**DCO Application for the Aquind Interconnector Project  
SDNPA Deadline 7c Submission**

I write to provide the following from the South Downs National Park Authority (SDNPA) at Deadline 7c:

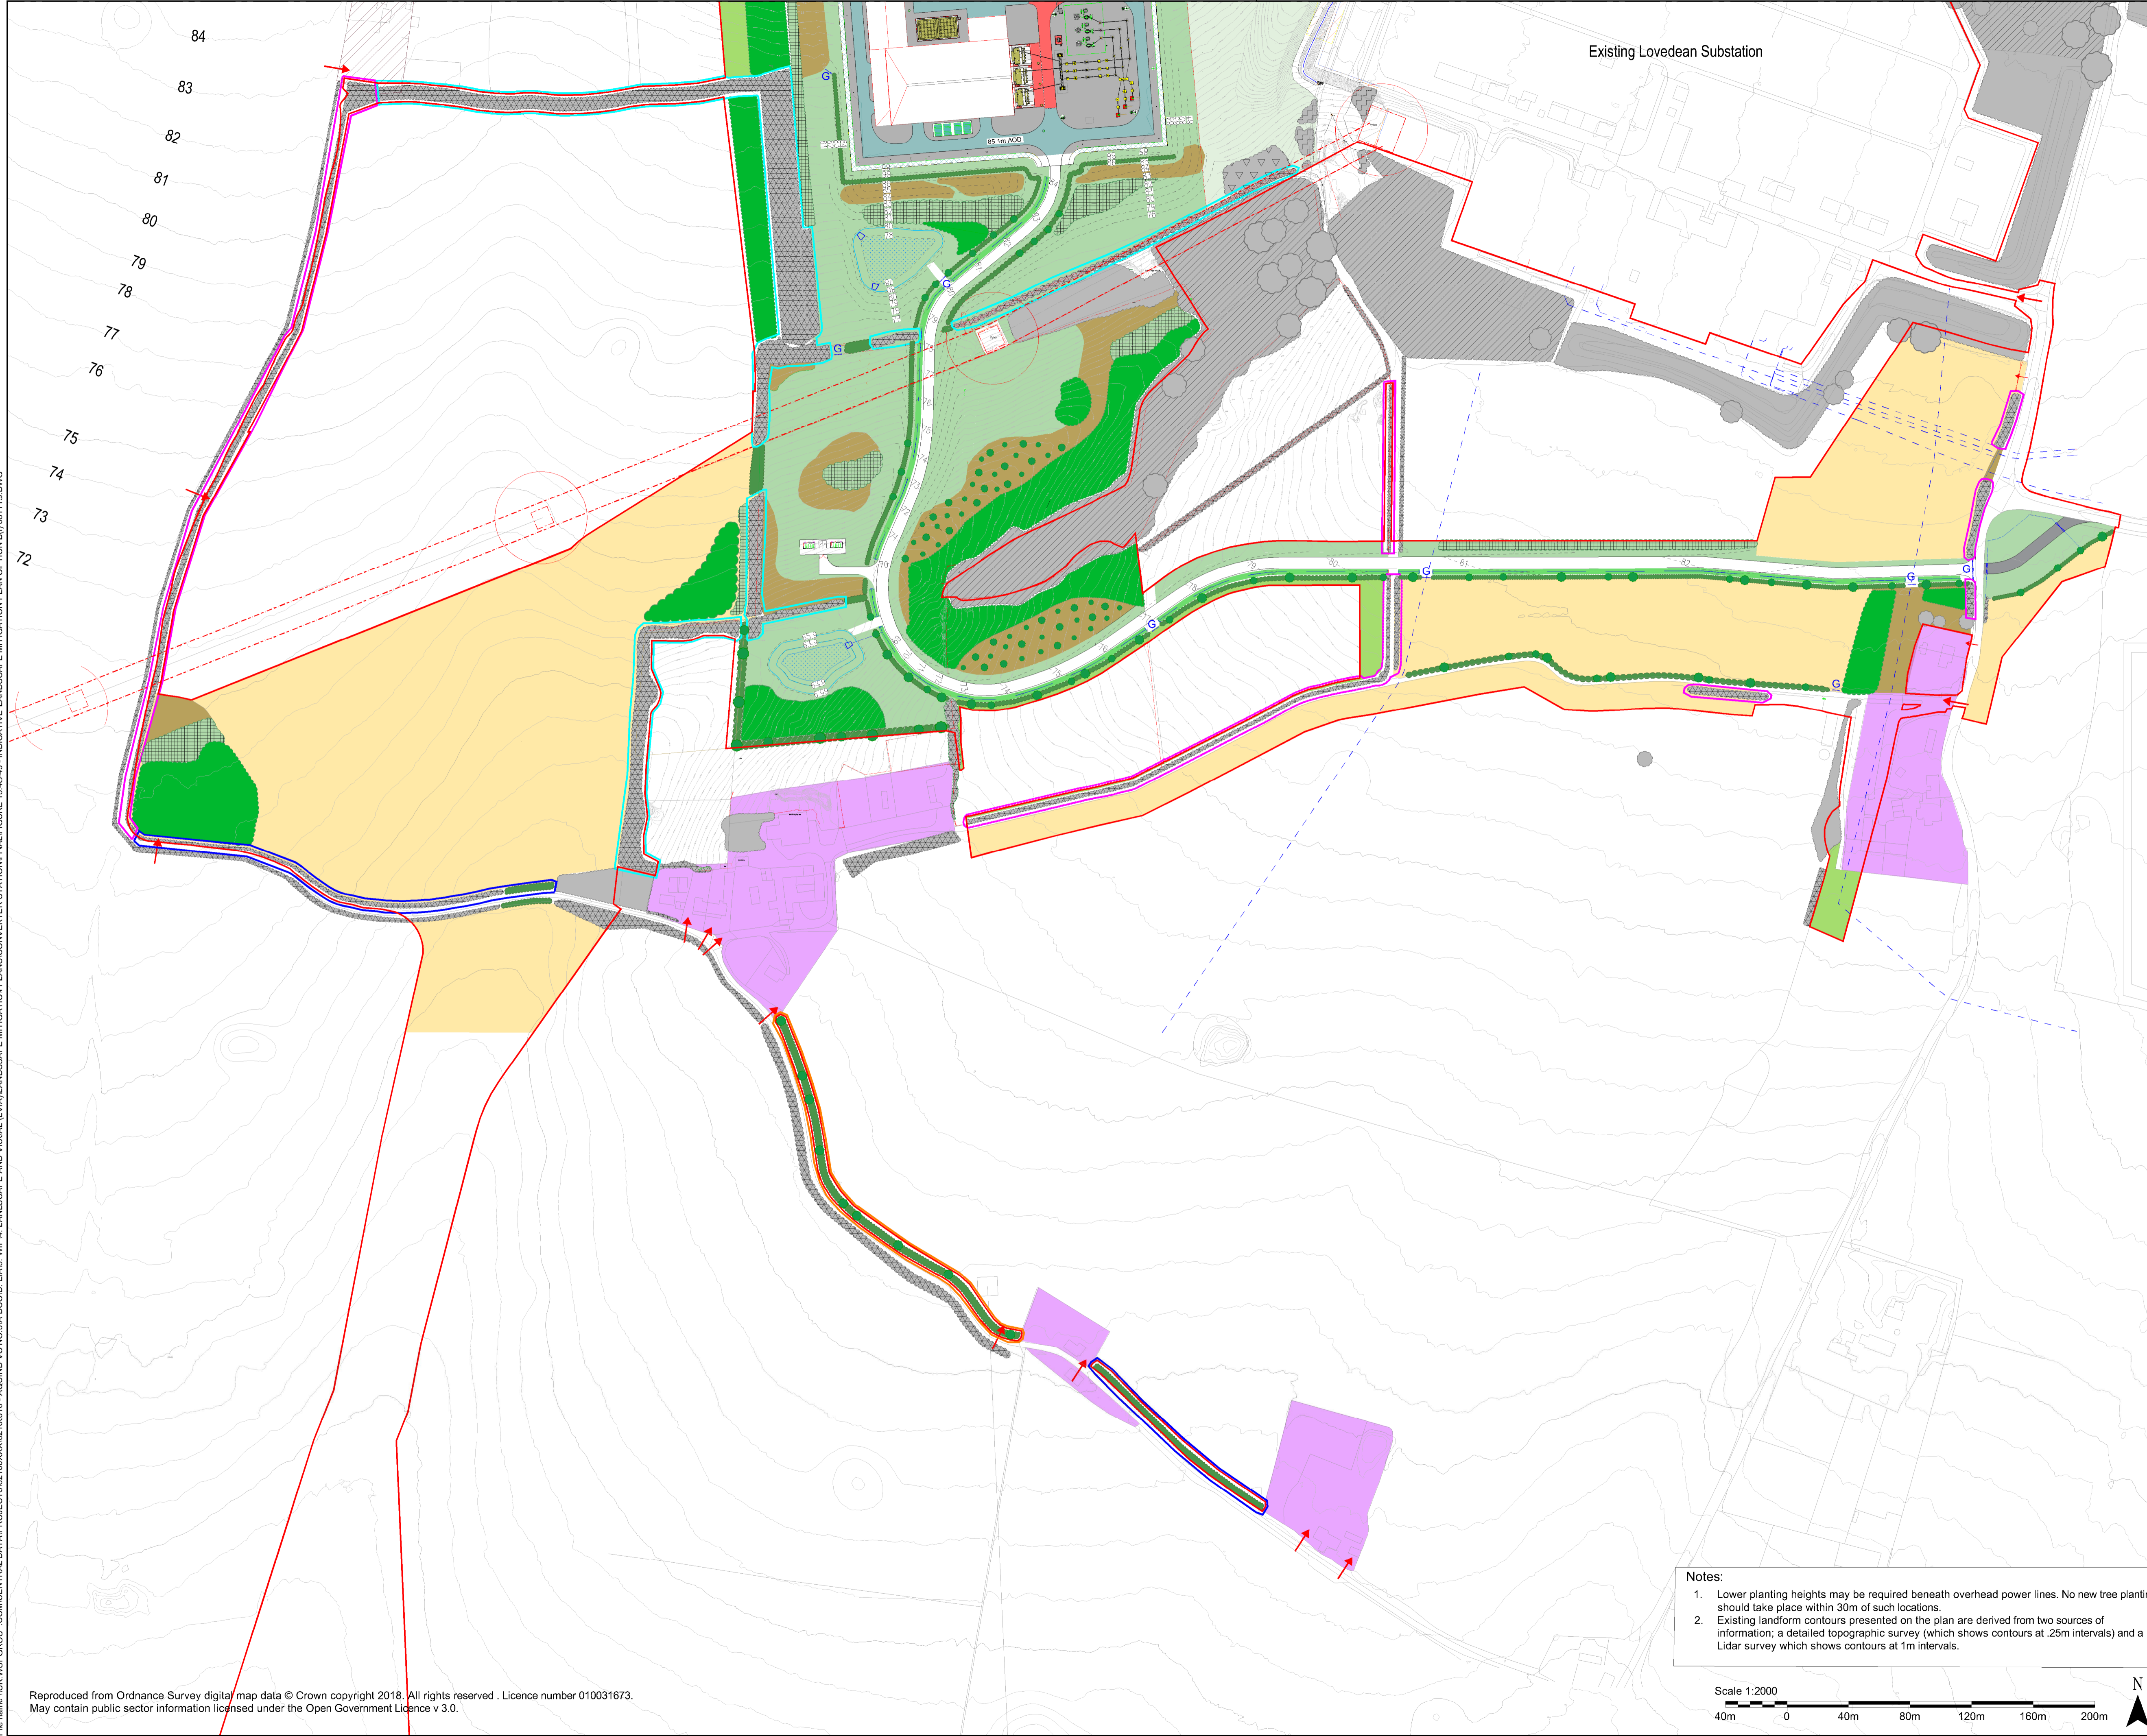
1. This latest version of the Outline Landscape and Biodiversity Strategy has removed reference to the previously proposed 10m strip of planting to the south of Mill Copse. This was previously indicated on the applicant's Landscape Mitigation plans, however the latest revision at deadline 7 has removed this.

This screening was identified as important by the applicant previously (Change Request Reference AS-054) in response to ash die back. The SDNPA would question the extent to which this reduces the effectiveness of the additional visual mitigation identified to be required in relation to ash die-back disease.

2. The SDNPA note that replacement planting proposed by the applicant within the existing woodlands, hedgerows and for individual trees is not indicated on the Landscape Mitigation Plans.

Compulsory Aquisition Hearing 1 – Appendix 1
- Exhibit 5 Drawing showing indicative
proposed haul road on the opposite side of
Day Lane

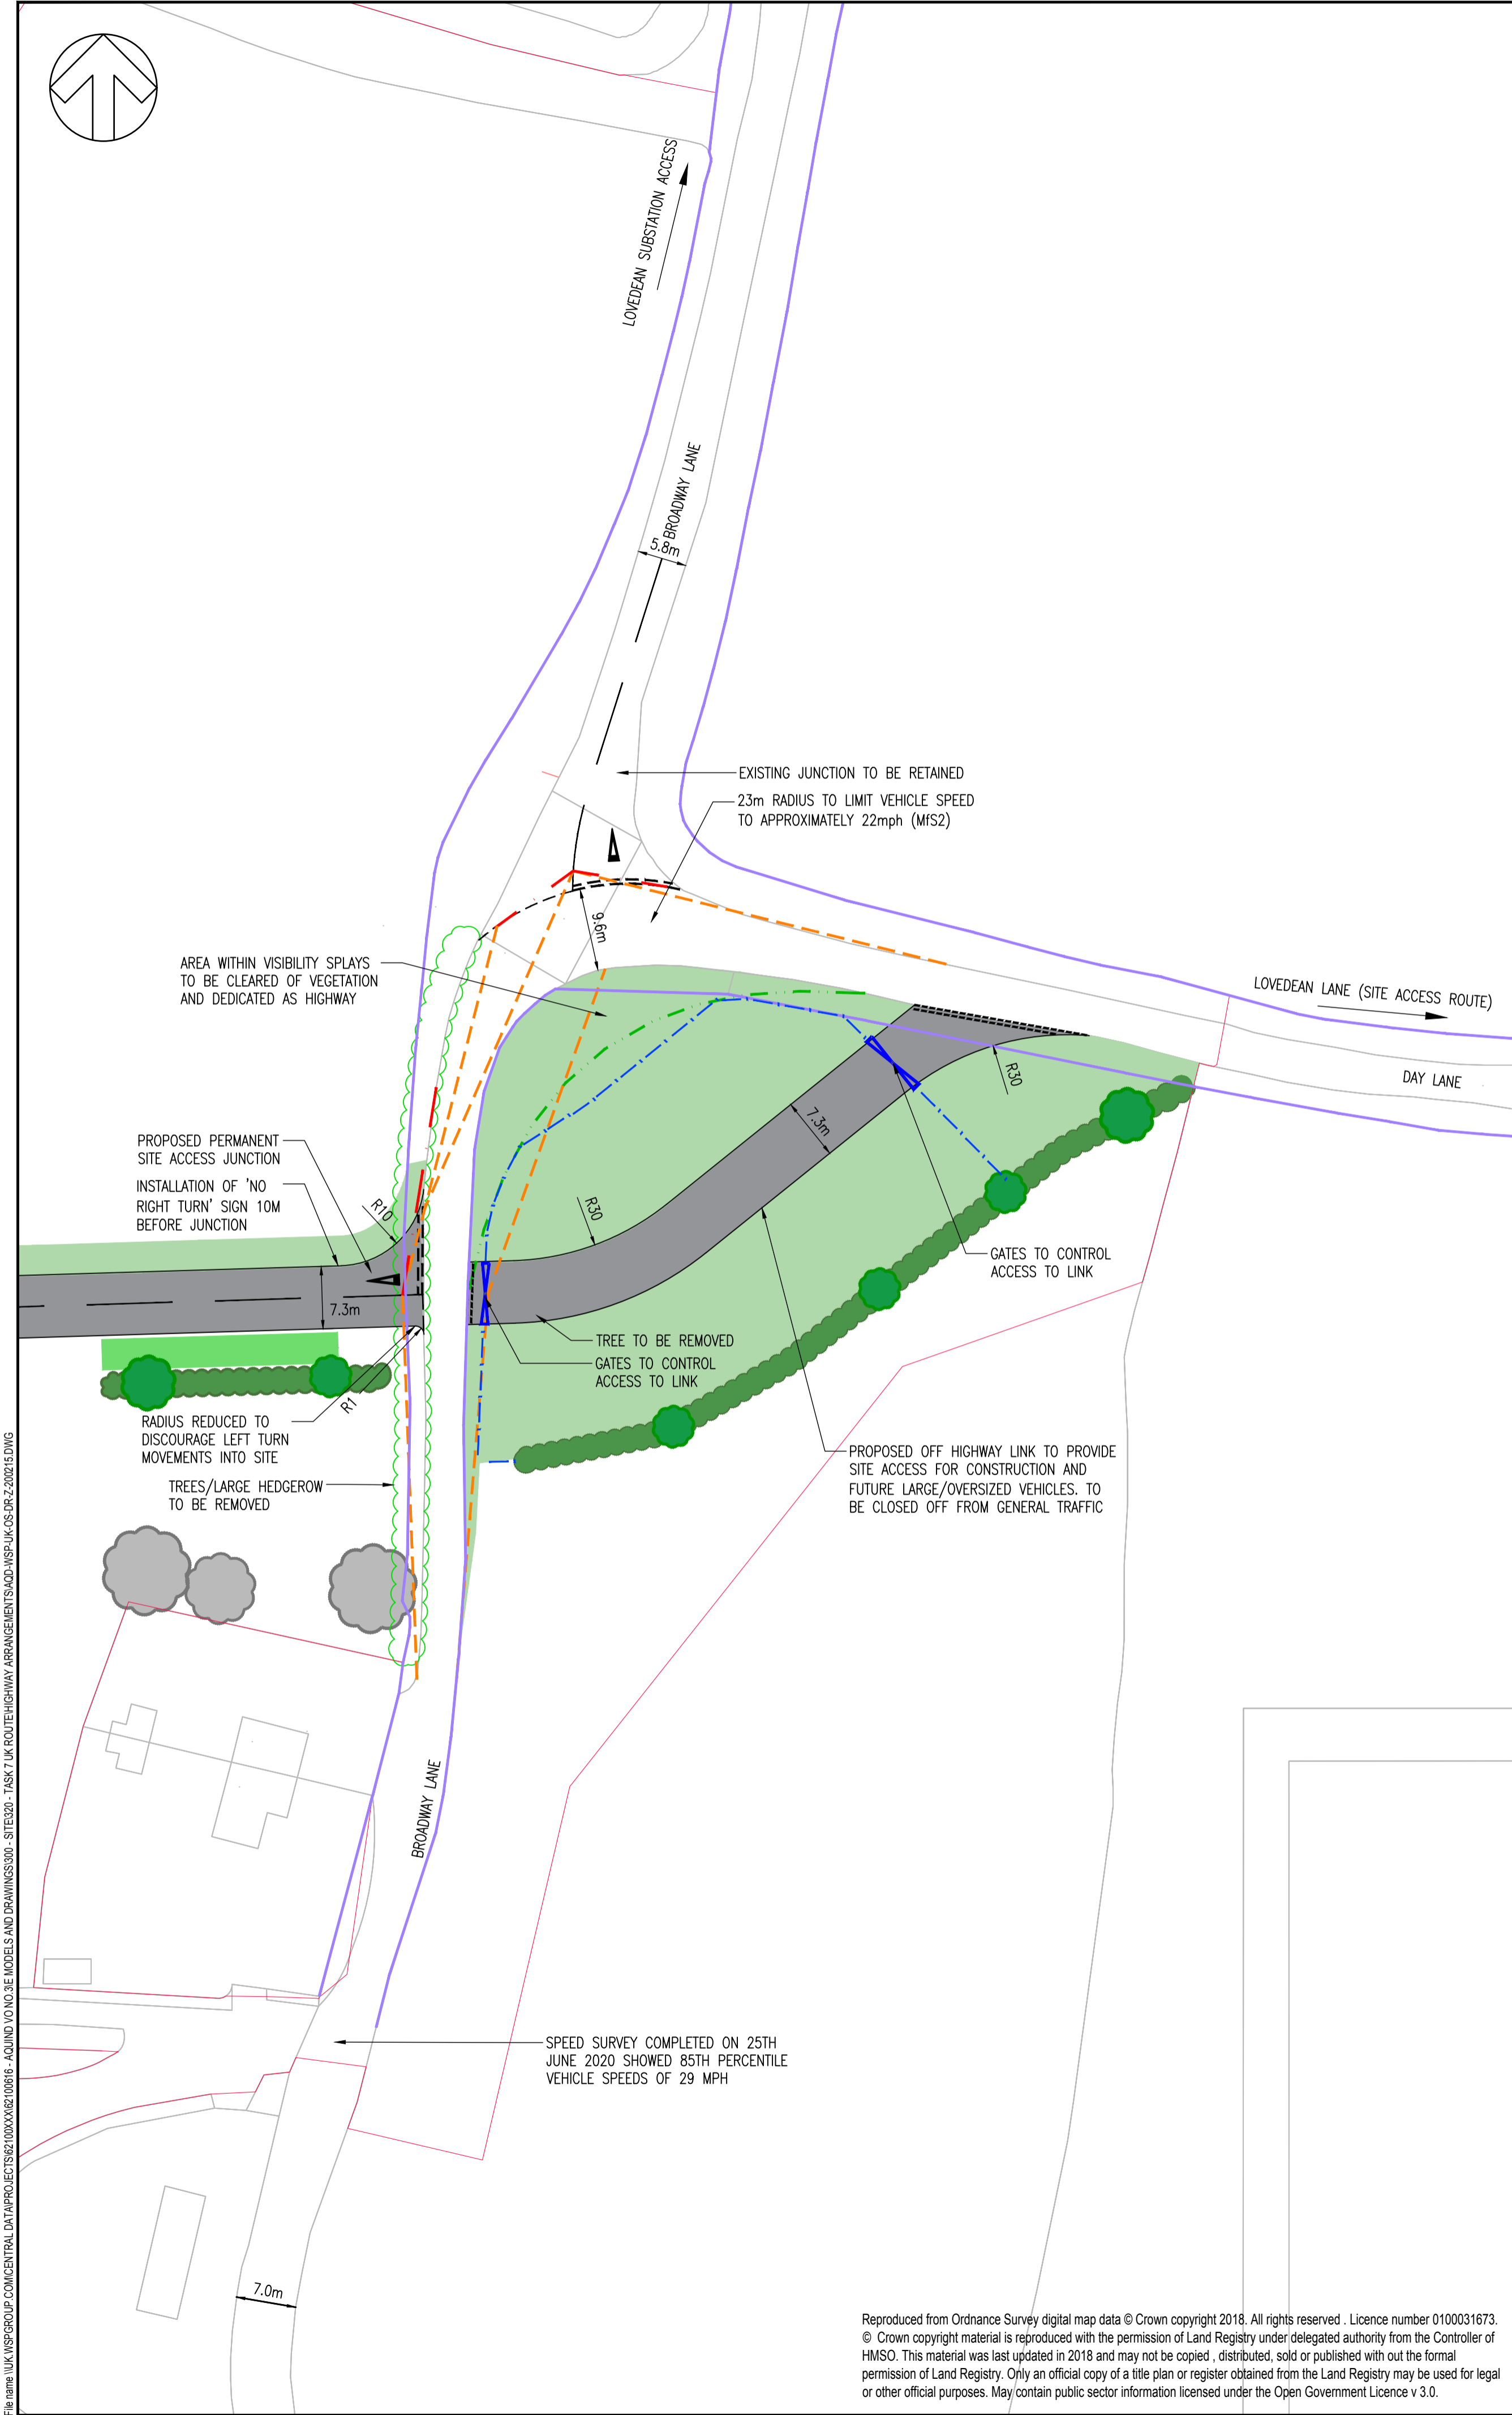
Road laybys are proposed which we understand lie within the highway boundary (and thus outside of the National Park). With reference to this change the Day Lane Technical Note makes no comment in respect of arboricultural or biodiversity matters, nor does it make any reference to impact on views.

In respect of views Monarch's Way runs across fields to the immediate north. Lorry movements during construction will have an adverse impact on views. It is accepted that the laybys themselves will not cause harm to views, however the laybys do represent a moderate erosion of the rural character of this lane. Will the applicant remove the laybys once they are no longer required?

- Layby a: grass area only – no concerns in respect of trees
- Layby b: tree RPAs may be affected – is there an arboricultural survey?
- Layby c: narrow verge. Hedge RPA may be affected, unless there is a ditch. If there is a ditch then is this affected?
- Layby d: narrow verge. Tree and hedge RPAs may be affected – is there an arboricultural survey, unless there is a ditch. If there is a ditch then is this affected?
